Ref: BR/113/17/PL

Construction of an Adventure Golf Course at Hotham Park

Further to your letter of 28th April please find below our comments, confirmations and attachments in respect of the points raised.

G-2701IE KIOSK PLAN

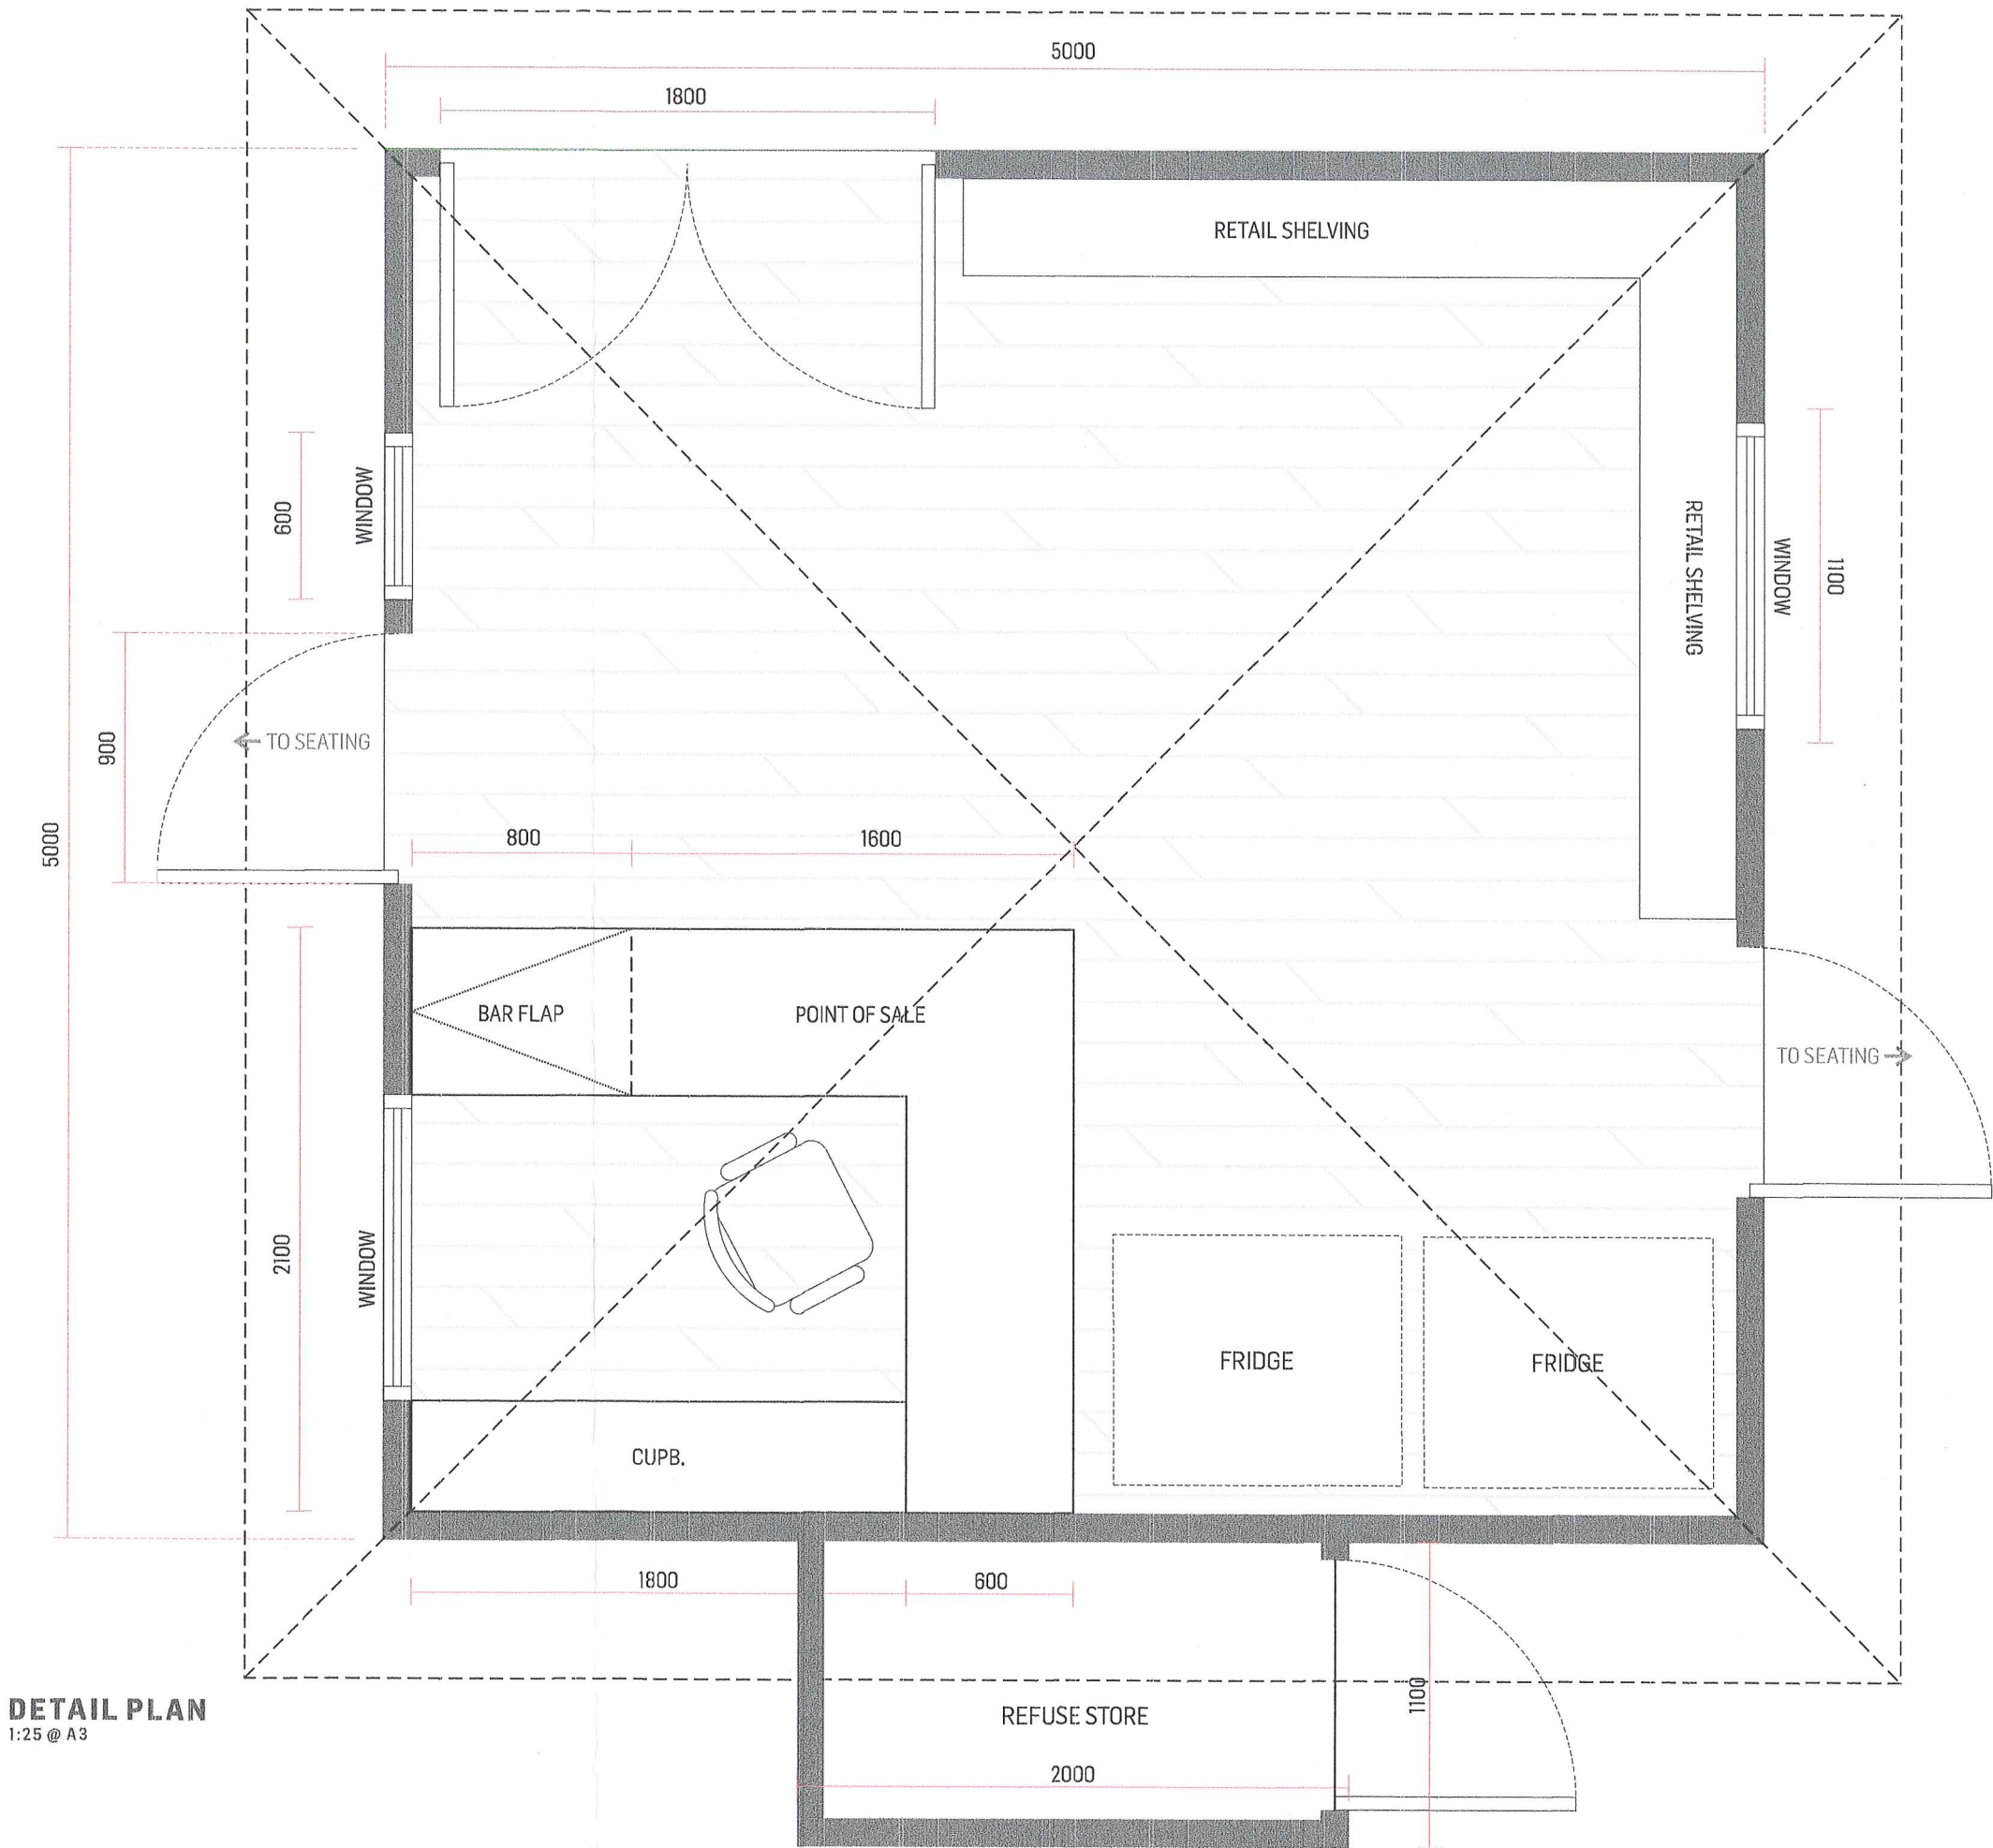
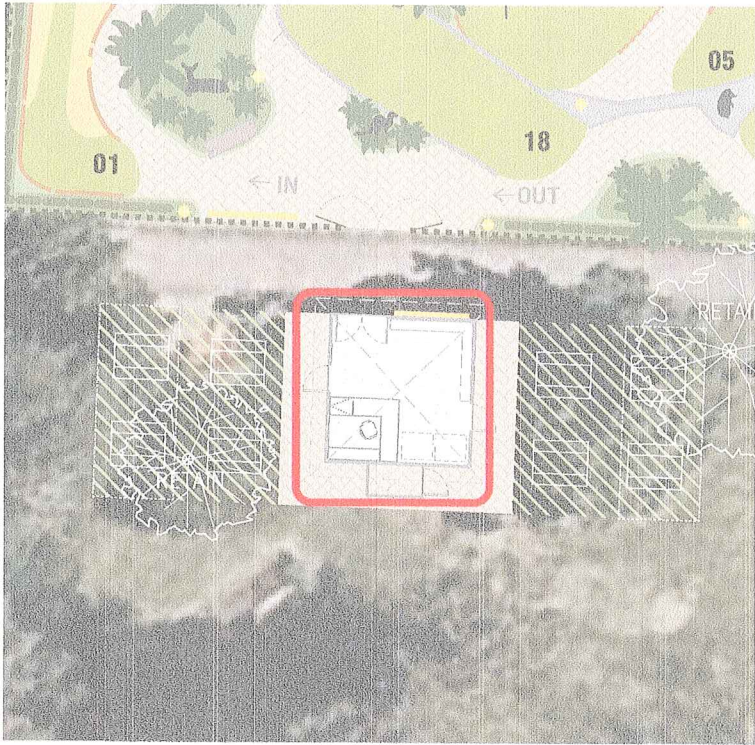
A drawing showing the proposed location of the bin/waste storage area is attached.

their existing arrangements making use of the additional provision for waste bin storage as indicated on the attached drawing G2701-E & G2702-E

02- PROPOSED KIOSK ELEVATIONS

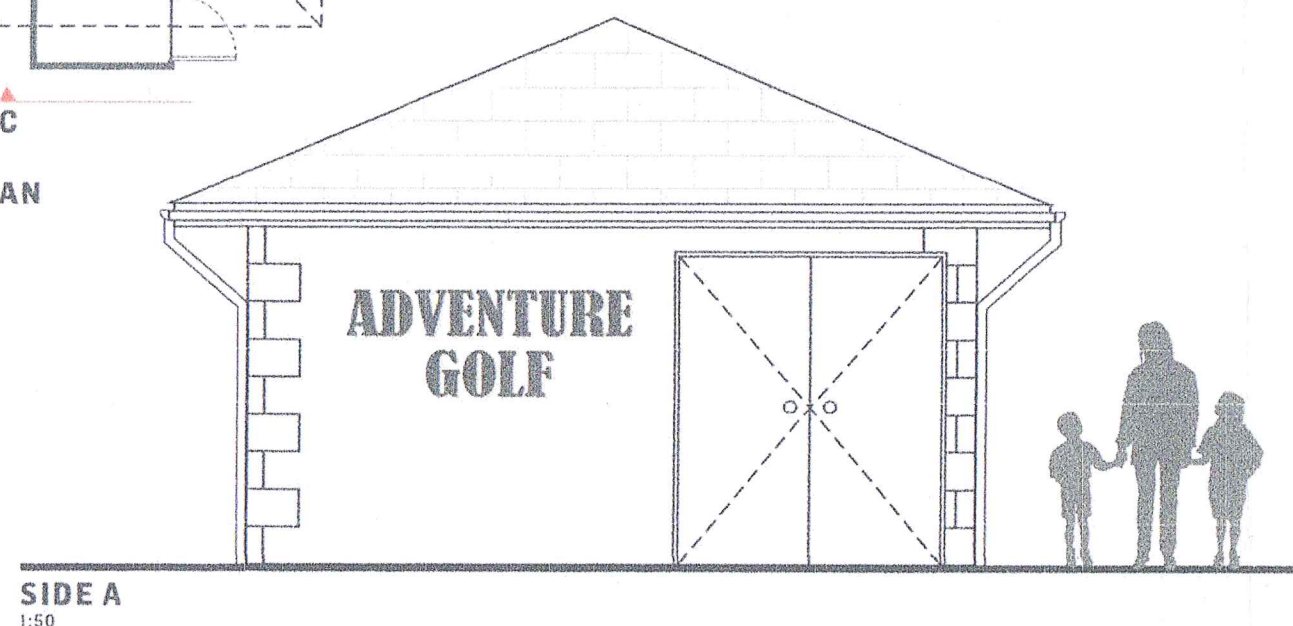
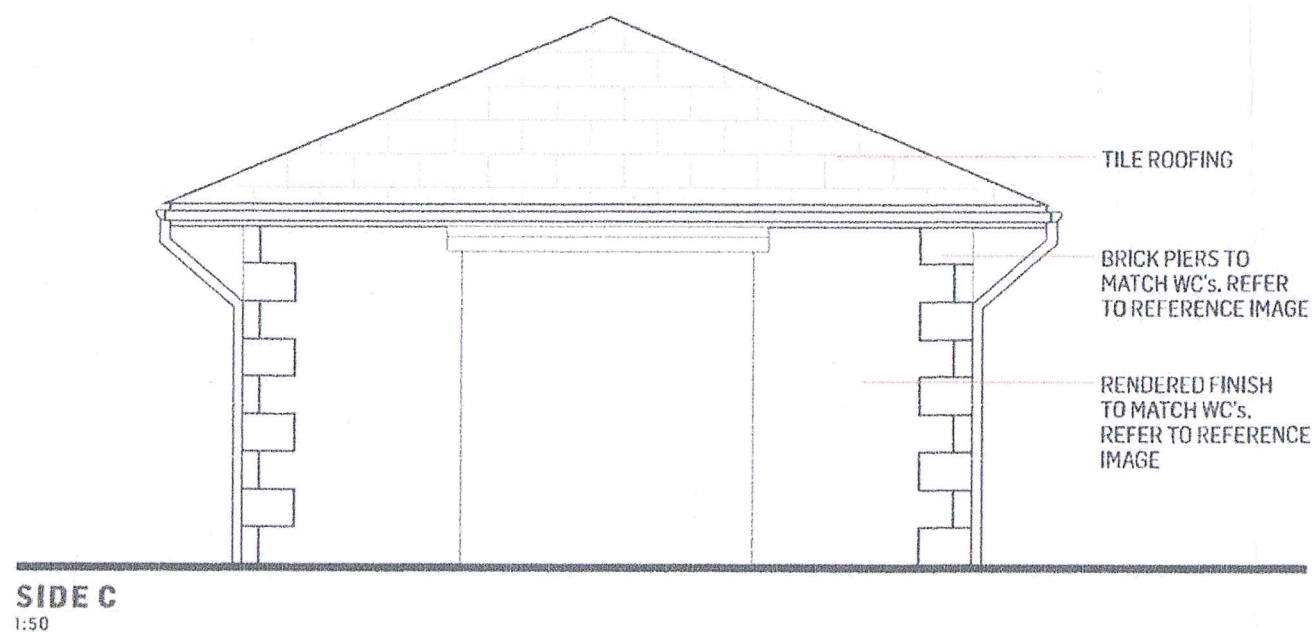
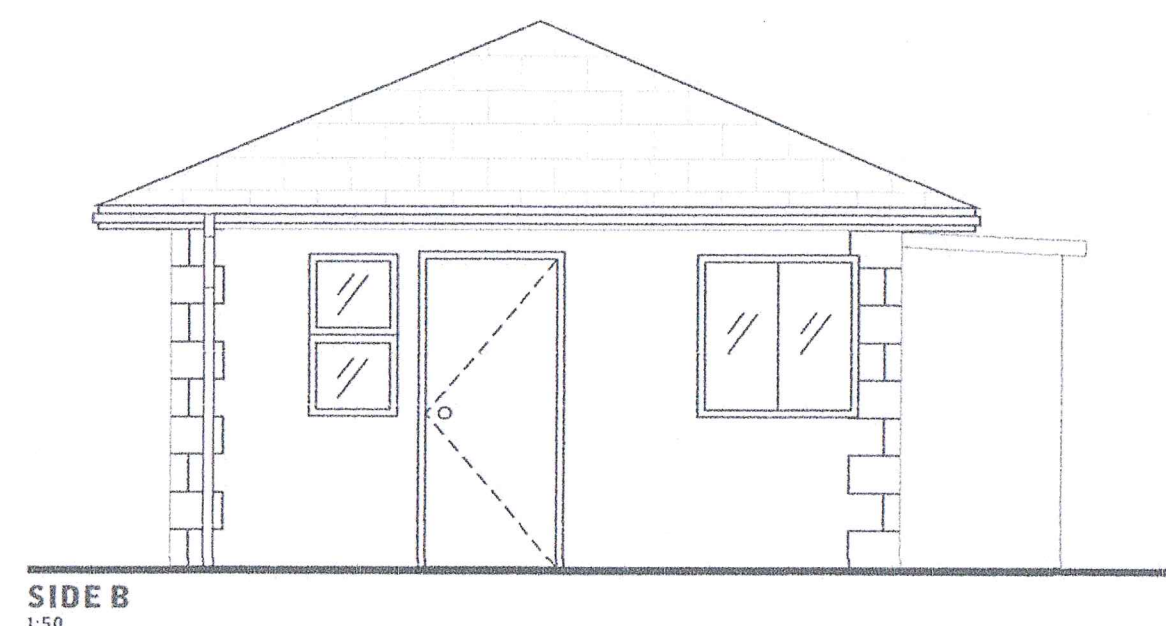
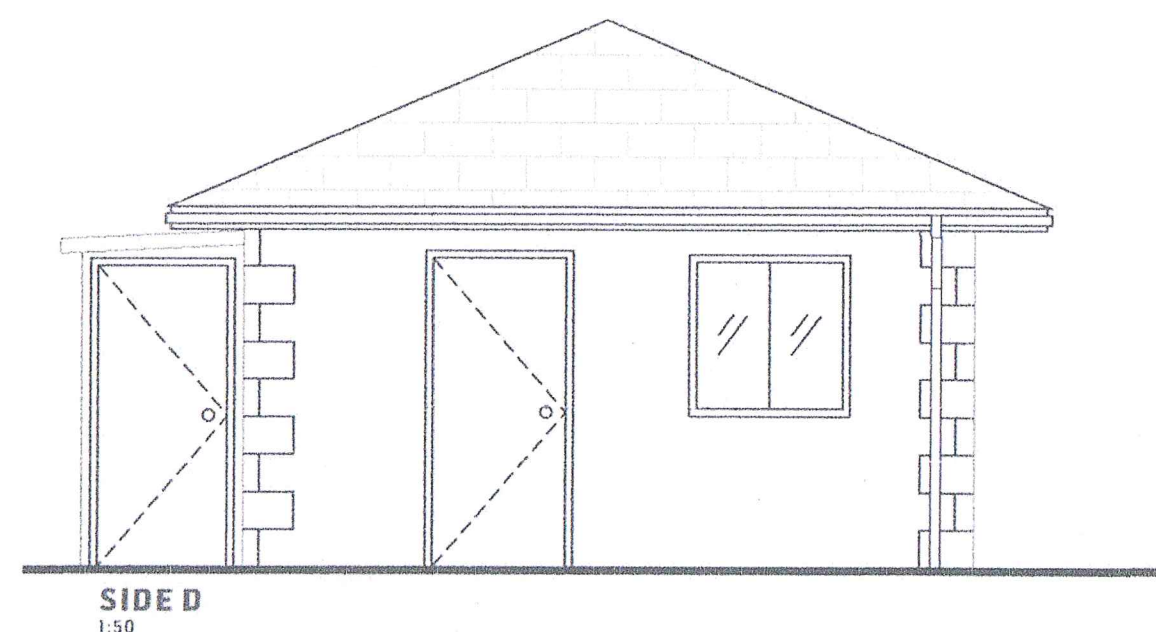
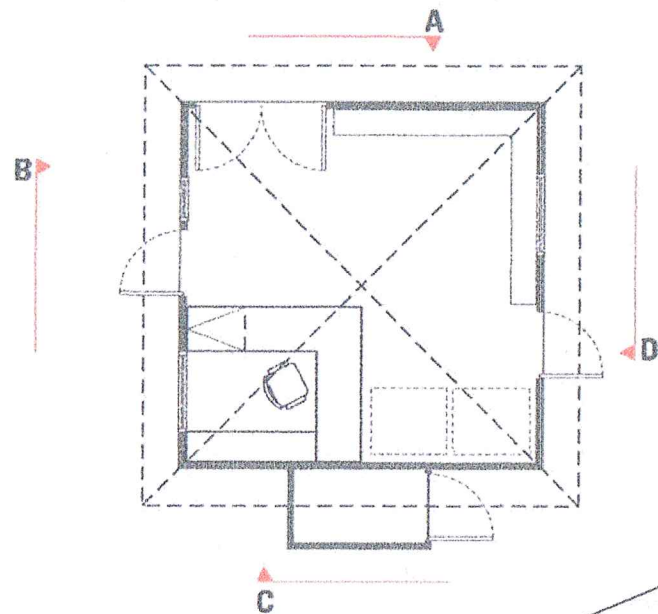
New Adventure Golf Kiosk as per drawing G2702-E will not have any water services and will therefore not require any foul drainage
